KIRKLEES METROPOLITAN COUNCIL INVESTMENT & REGENERATION SERVICE

DELEGATED DECISION TO DETERMINE APPLICATIONS FOR LISTED BUILDING CONSENT

Reference No:	2021/65/94500/W
Site Address:	5-7, Dundas Street, Huddersfield, HD1 2HE
Description:	Listed Building Consent for removal of external steps
Recommending Officer:	Sue Brooks

REF.	DATE	REVISIONS	
Streetscene & Housing Highway Safety, Flint Street, Fartown Huddersfield, HD1 6LG			
SECTION PUBLIC REALM			
DRAWN FEC		CHECKED ST	
SCALE	PROJECT NO. 25/65053	DATE NOV 21	
PROJECT DUNDAS STREET, HUDDERSFIELD			
TITLE CONSULTATION PLAN			
DRAWING No. 25/65053/GA/DS/04		CAD No.

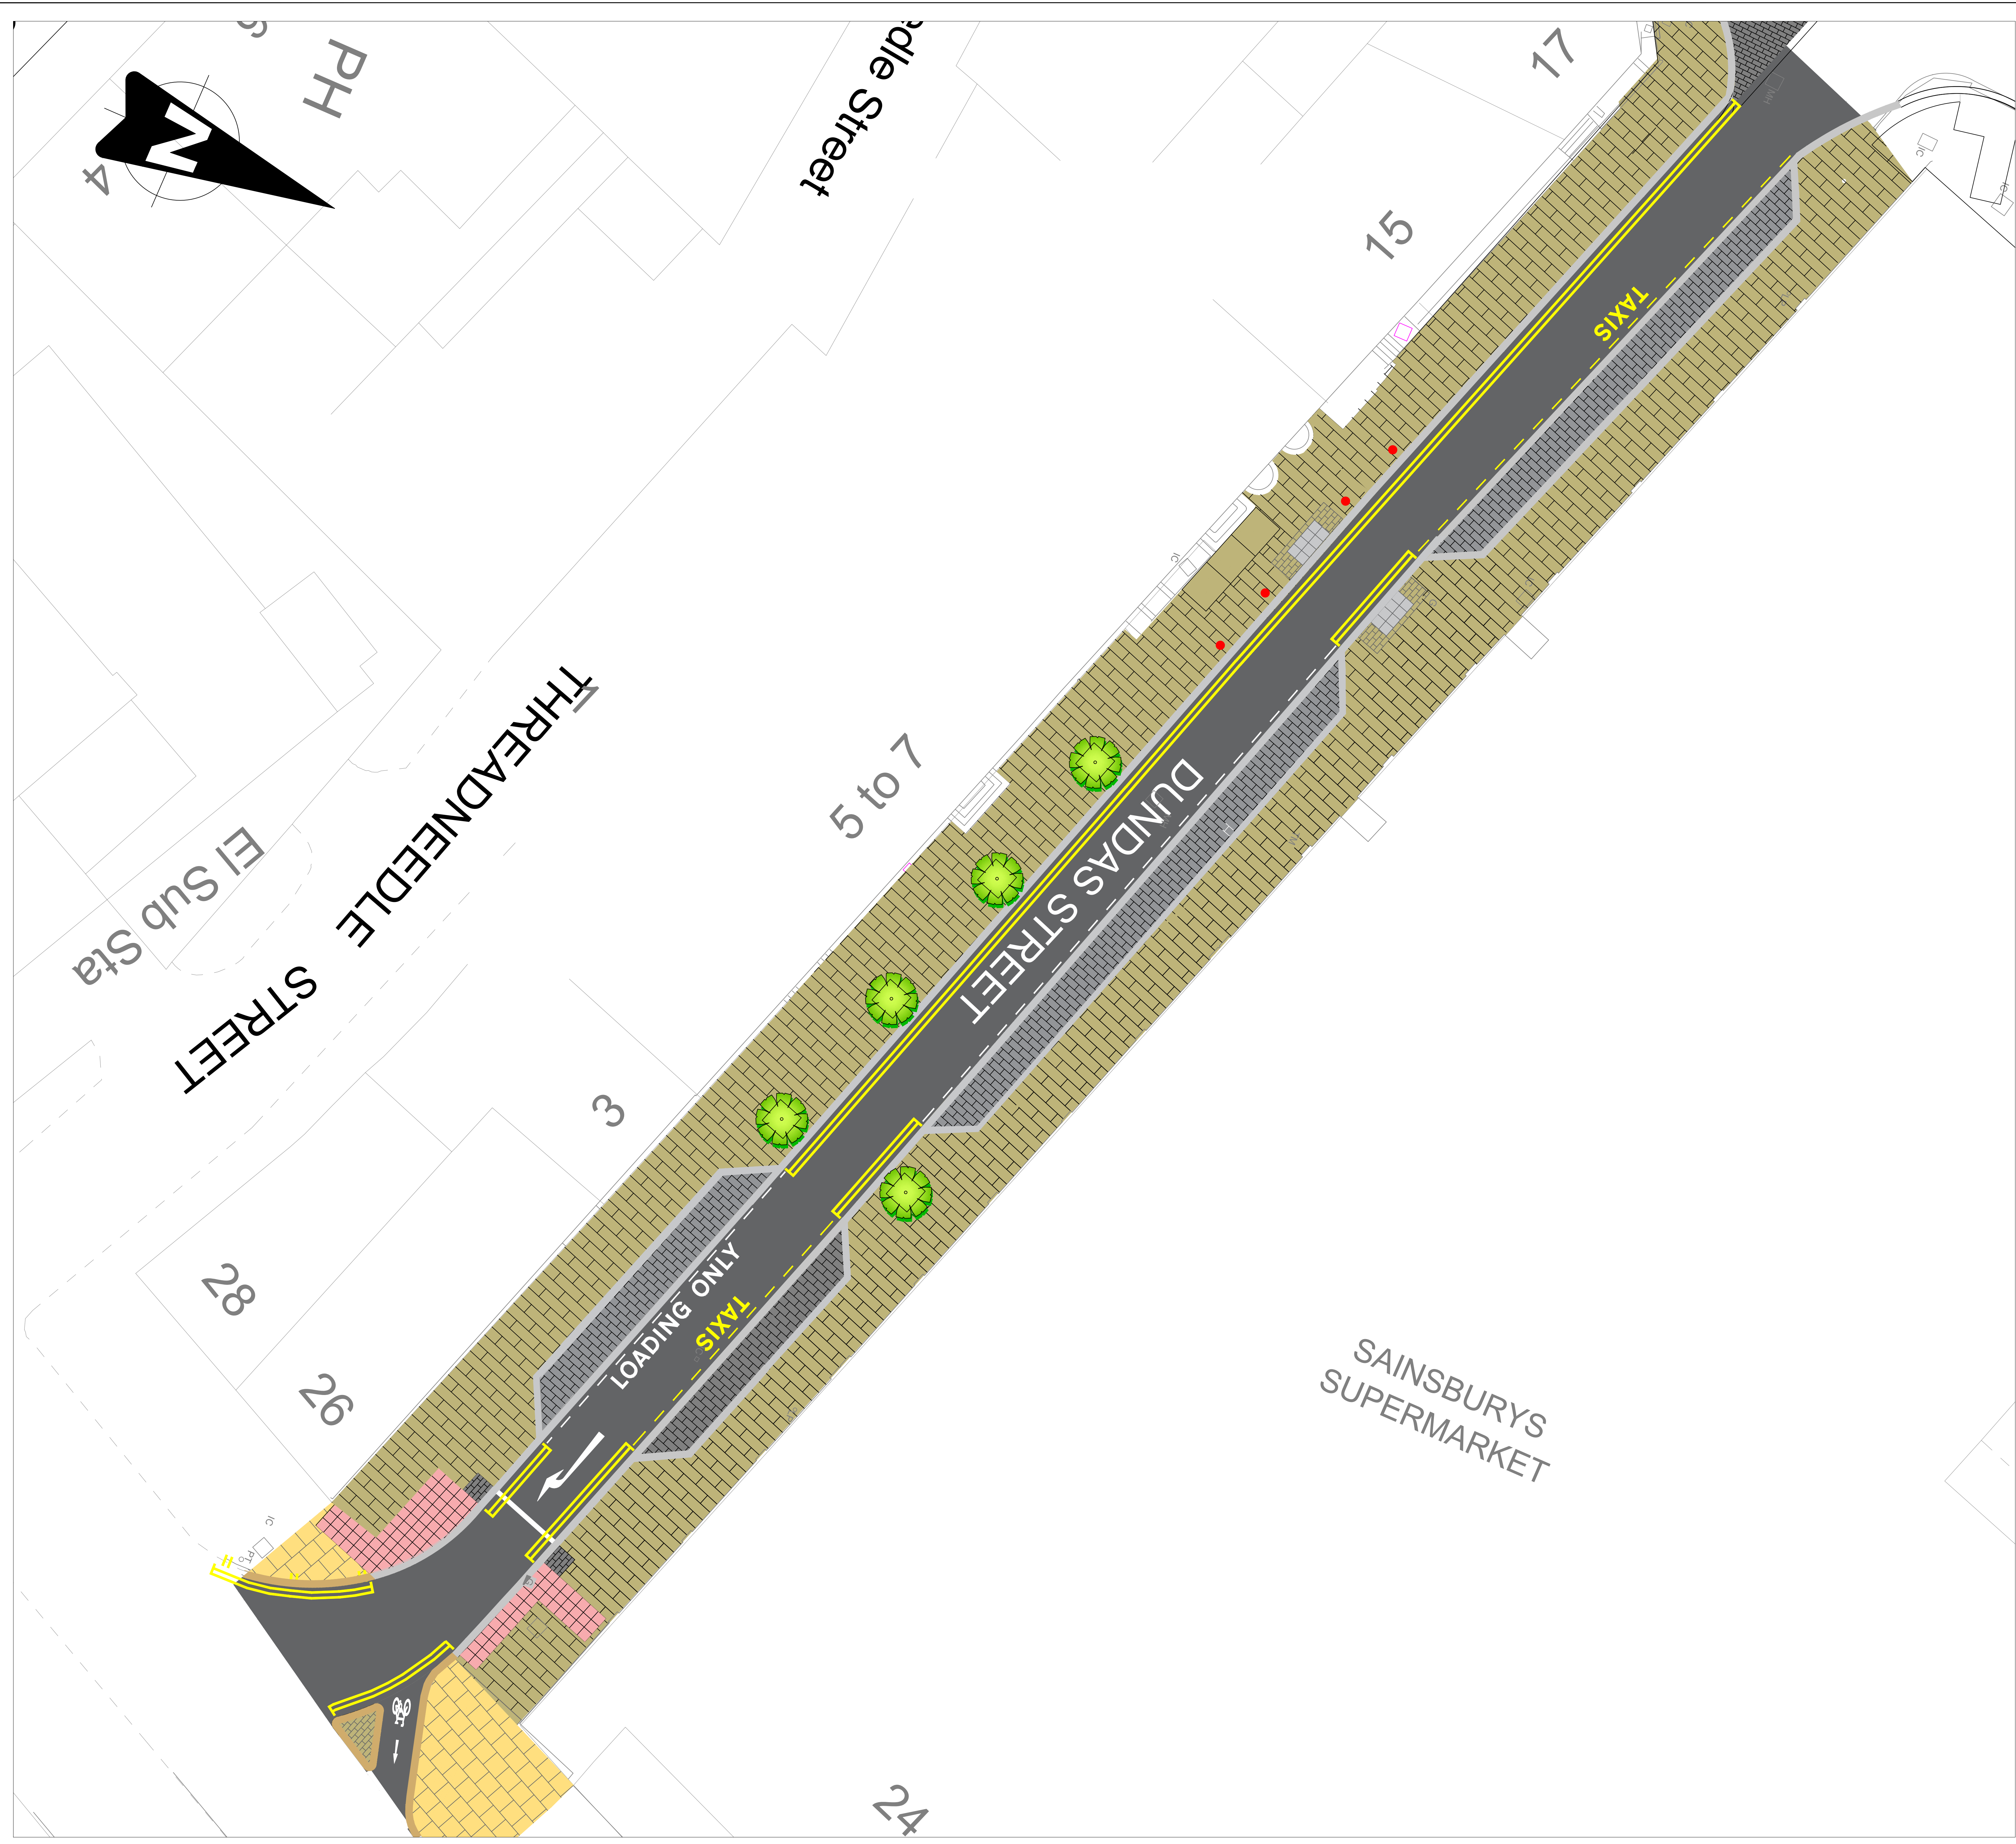
The proposal is for the removal of the external stone steps in front of the redundant doorway facing Dundas Street.

Historic maps show that a set of steps were in place in 1890, which indicates that the existing steps are contemporary with the building. They are located in front of a former doorway which has been partially blocked up and converted into a window, and although they no longer have a function, they indicate the position of the original entrances.

The removal of the steps would lead to a degree of less than substantial harm to the significance of the listed building by reducing its legibility, however the doorway is redundant and has been for some time, and the level of harm is therefore low. The proposal is part of a wider scheme to enhance the public realm on Dundas Street, creating wider footways which will give pedestrians priority over vehicular traffic and provide safer and more accessible space.

The removal of the redundant steps will reduce obstacles for pedestrians on the reconfigured footway.

Once the steps are removed the footways will be paved in stone flags, which is consistent with the historic character of the town and will greatly enhance this street.

On balance, the public benefits of enhancing the public realm and reducing obstacles on the footway will outweigh the low level of harm caused by the loss of historic fabric. A condition has been applied to ensure that the wall behind the steps is made good following the removal of the steps.

3. Following removal of the steps, the stonework of the façade shall be repaired, with pointing in a lime-based mortar and flush pointed to match the surrounding stonework. If replacement stones are required these shall match the low-level stonework in terms of coursing, joint size stone type and finish.
